From: [Rob Green](#)
To: [A38 Derby Junctions](#)
Cc: [Stewart Emily](#)
Subject: A38 Derby Junctions submission
Date: 26 March 2020 23:30:32

a) Assessment of junction capacities

b) Junction Geometry

Drawing Title  
FIGURE 2.6  
MARKEATON JUNCTION  
GENERAL ARRANGEMENT

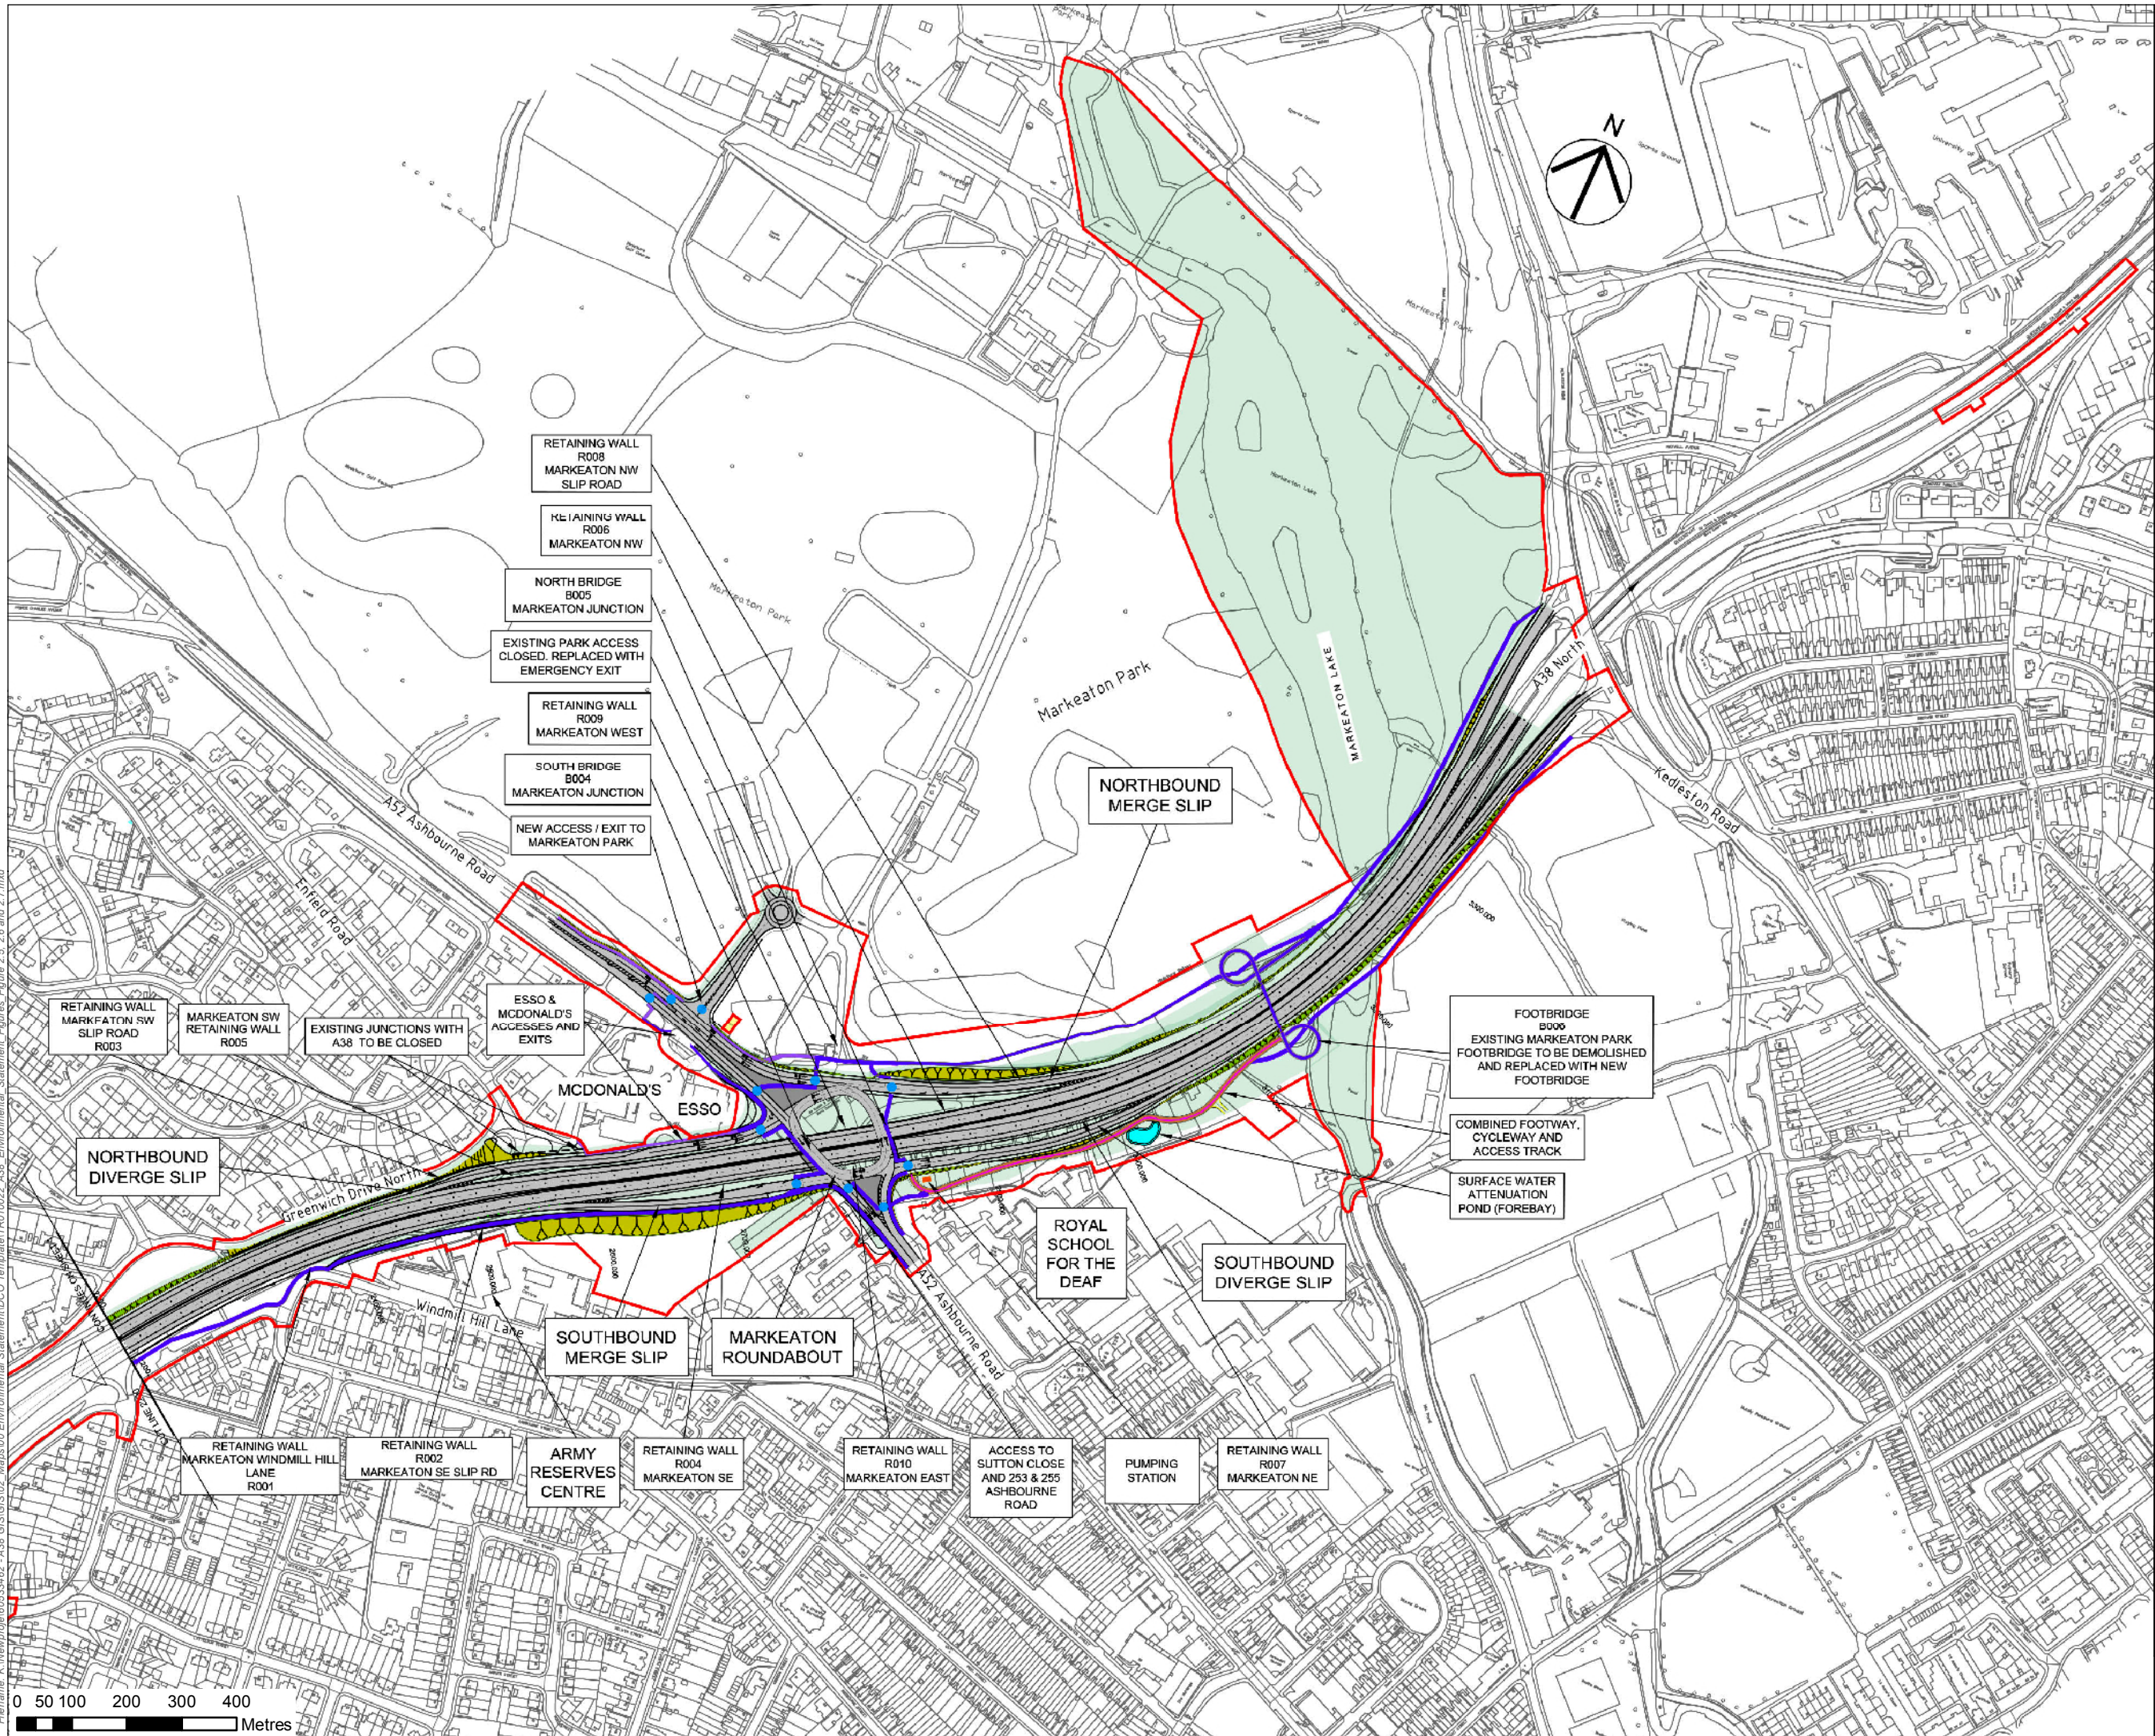
HE note that the A52 entry layout is similar to the existing arrangements, however, overlook that all site traffic will need to use the new access, whereas presently, traffic can access the site from the A38. Swept paths have been prepared by HE and they note both rigids and artics can safely negotiate. They are shown to have almost zero allowance for driver variation or error. Tracking software assumes that a vehicle is in an optimum situation with a competent driver, a vehicle in good working order (i.e. correct tyre pressures) on a relatively level camber and gradient, and in dry conditions. In addition to this, Tracking software assumes that the vehicle is not fully laden. Therefore there is a definite possibility that a fully laden delivery to McDonald’s, the PFS, or and HGV customer to the PFS could struggle to replicate the swept paths produced by HE. The manufacturers of tracking software note that a fully laden HGV with twin axles could have its turning circle affected by up to 0.5m while fully laden an manoeuvring close to, or at “full lock”.

It is our view that despite the modelling exercises and swept paths prepared to date, that the proposed junction is compromised in terms of both the storage space for vehicles seeking to exit McDonald’s or EuroGarages, and the tight and precise manoeuvres required for each and every HGV arriving at the site, in order to access the site safely.

Despite recent comments from HE we do not consider that the issue in their own safety audit has been satisfactorily addressed:

“The proposed access into the new Esso/McDonalds access appears tight. If vehicles cannot safely turn into the access from Markeaton roundabout kerb strikes may occur or grazing collisions with vehicles waiting to turn right out of the junction onto the A52.”

Even if the scheme is “very similar” to the current arrangements, the necessary increase in use of the A52 access following the closure of the A38 represents an unreasonable intensification of use of a junction, which “appears tight”.
